From: Paul Cann <Paul.Cann@arun.gov.uk>
Sent: 06 May 2022 16:00
To: Planning.Responses <Planning.Responses@arun.gov.uk>
Cc: Sarah Burrow <Sarah.Burrow@arun.gov.uk>
Subject: RE: Planning Consultation on: BN/57/22/DOC

Application No: BN/57/22/DOC
Registered: 29th April 2022
Site Address: Land adjacent to 49 Warren Way Barnham PO22 0JX
Description of Works: Approval of details reserved by condition imposed under ref BN/152/20/PL relating to Condition Nos 3 - surface water drainage and 4 - discharge flows to watercourses.

Appendix H Proposed Surface Runoff Improvement Measures (SuDS)

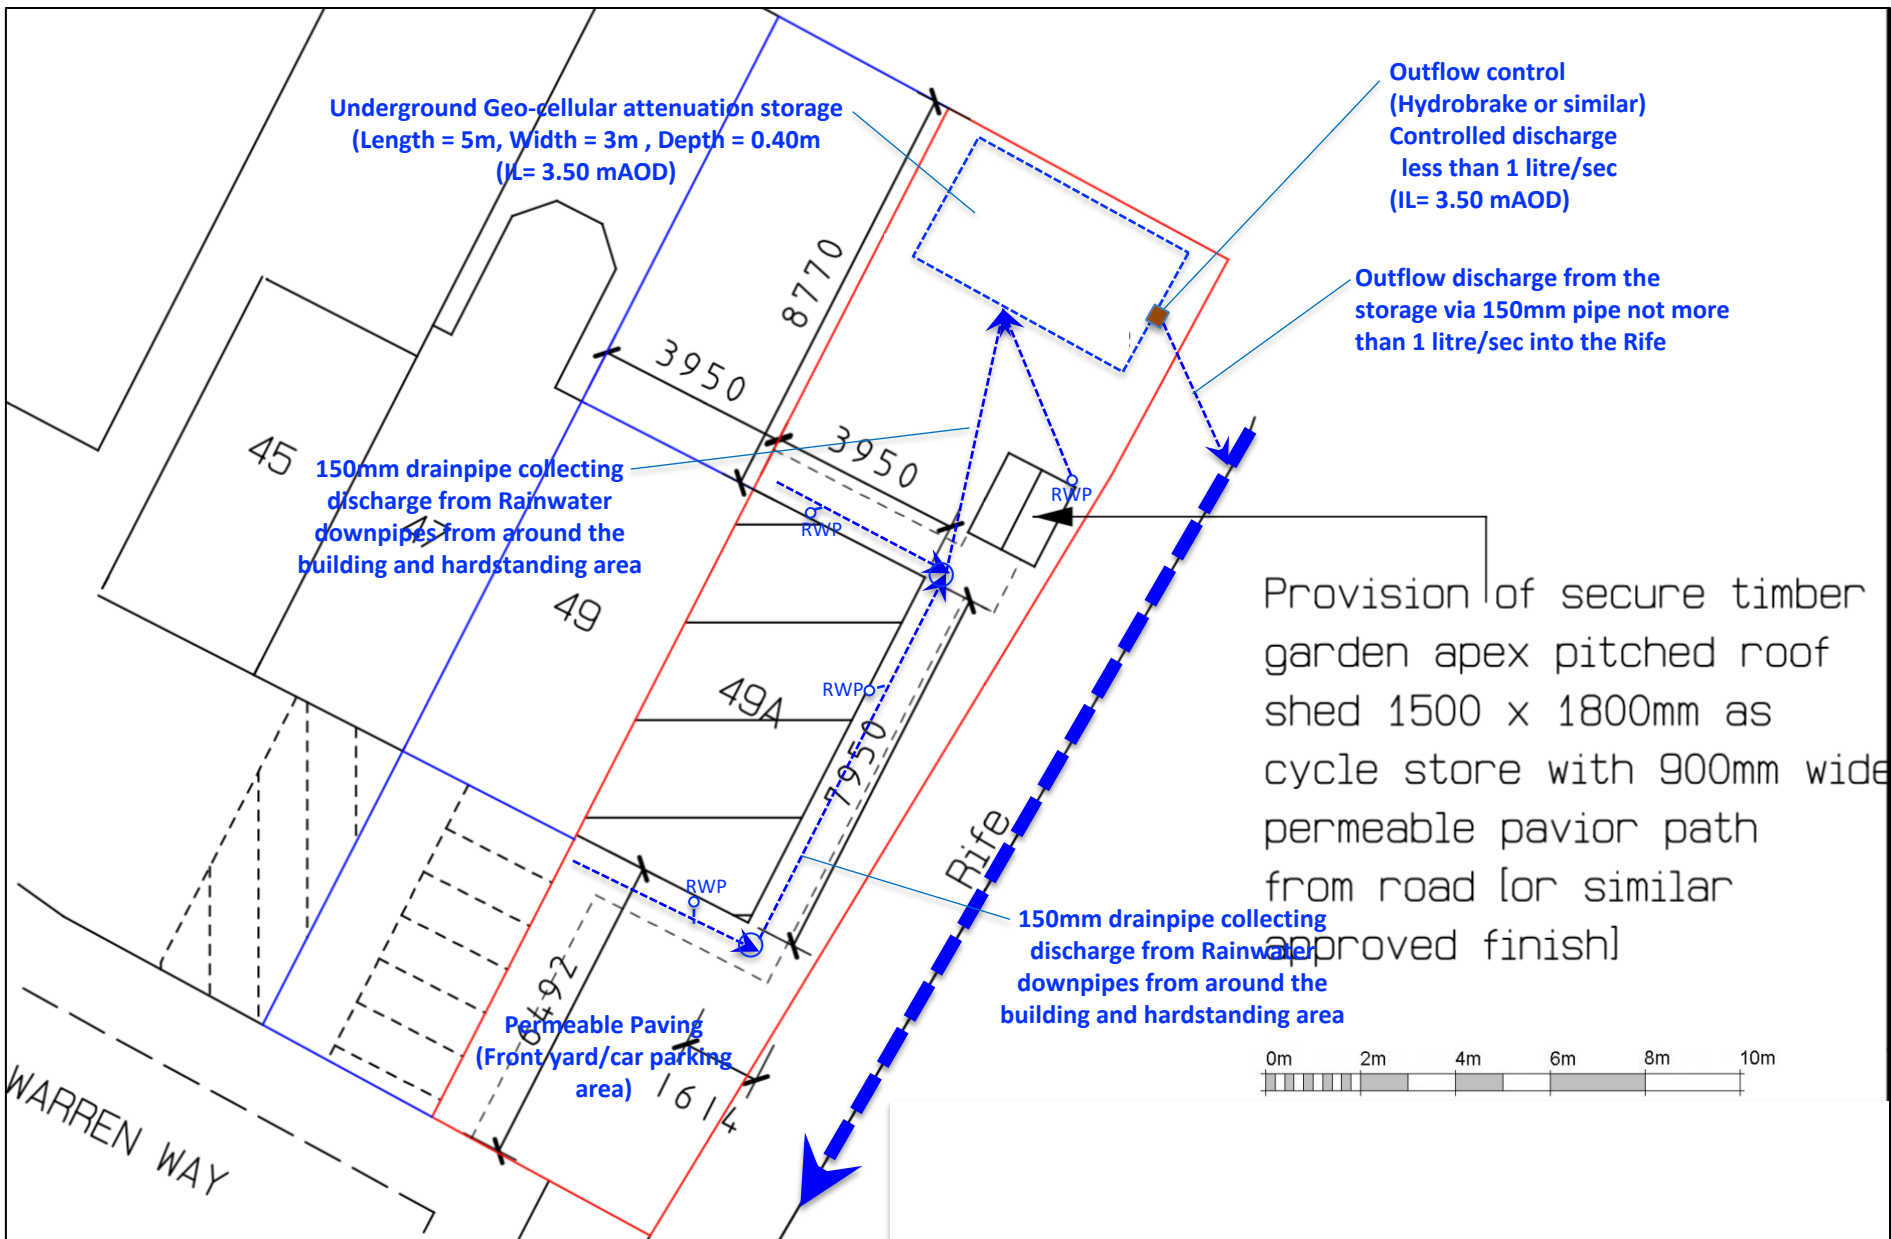
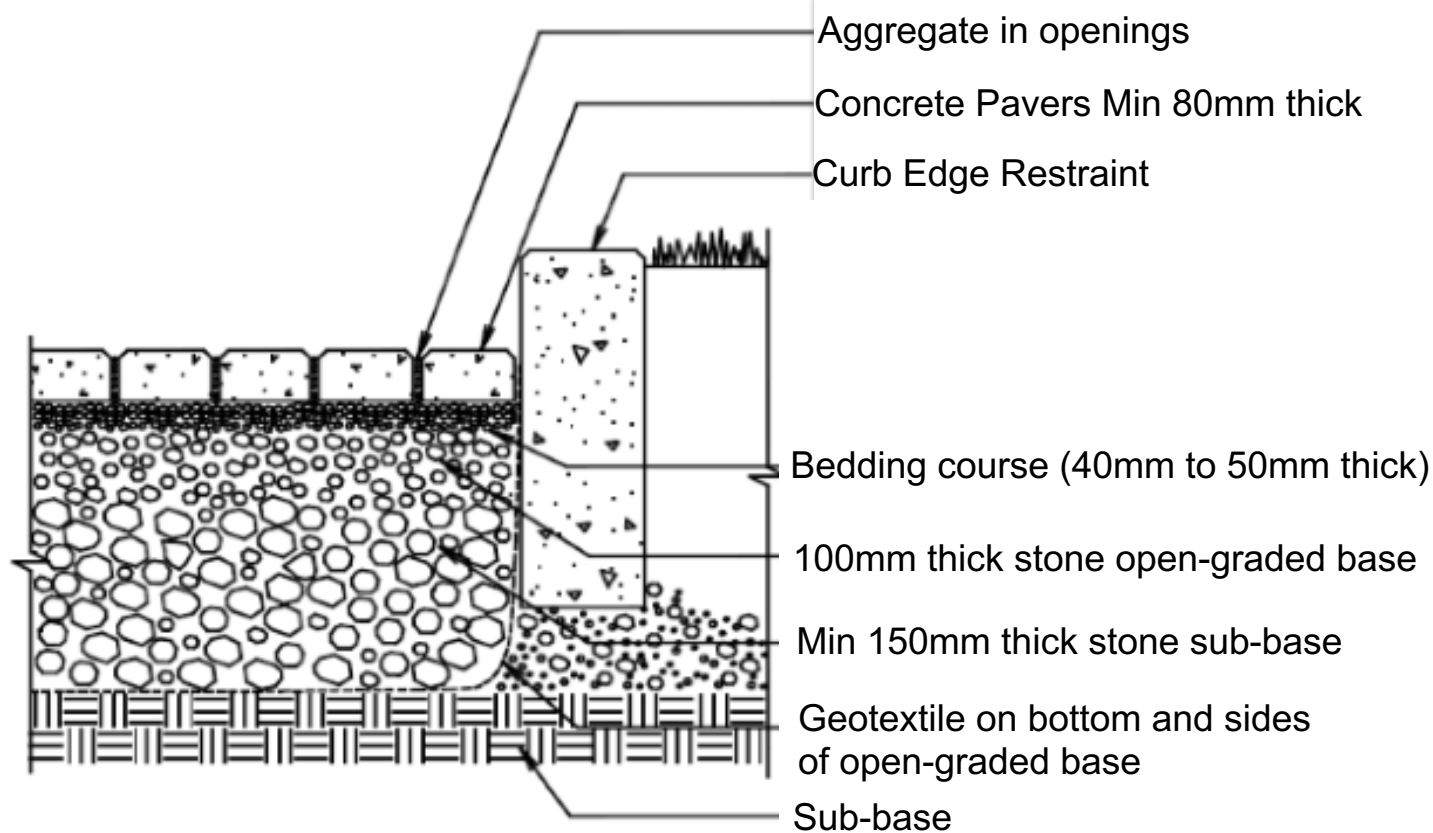
- *The drainage design to include **all** drainage features, e.g. manholes, catchpits etc.*
- *Construction detail drawings of attenuation tanks, flow control devices, pipe bed and surround, headwall, and catchpits (which should be located upstream of the tank).*

- *Construction detail drawings to include any vent structures for the tank, and/or other similar features. Vents will need to be located above the design flood level, to prevent water ingress into the tank during a flood.*

- *The permeable paving construction detail must include material specifications, e.g. type of stone for sub-base.*
- *Details of the downpipe covers, which have been referenced in previous correspondence.*

- *Details of the water butt, which have been referenced in previous correspondence. The drainage drawing should show details of the inlet, outlet, overflow system, and stand provided.*

- *The minimum orifice diameter for the Hydro-Brake and any flow control device will need to be 75mm, or discharge at a flow rate of 2.0l/s.*
- *We also note that the 'sump available' option has been ticked in the drainage calculations. If a Hydro-Brake with sump available is specified, as is indicated by the calculations, this sump will need to be included on the drainage drawings. Please note that this sump cannot be substituted for the upstream sediment traps, that are also required.*
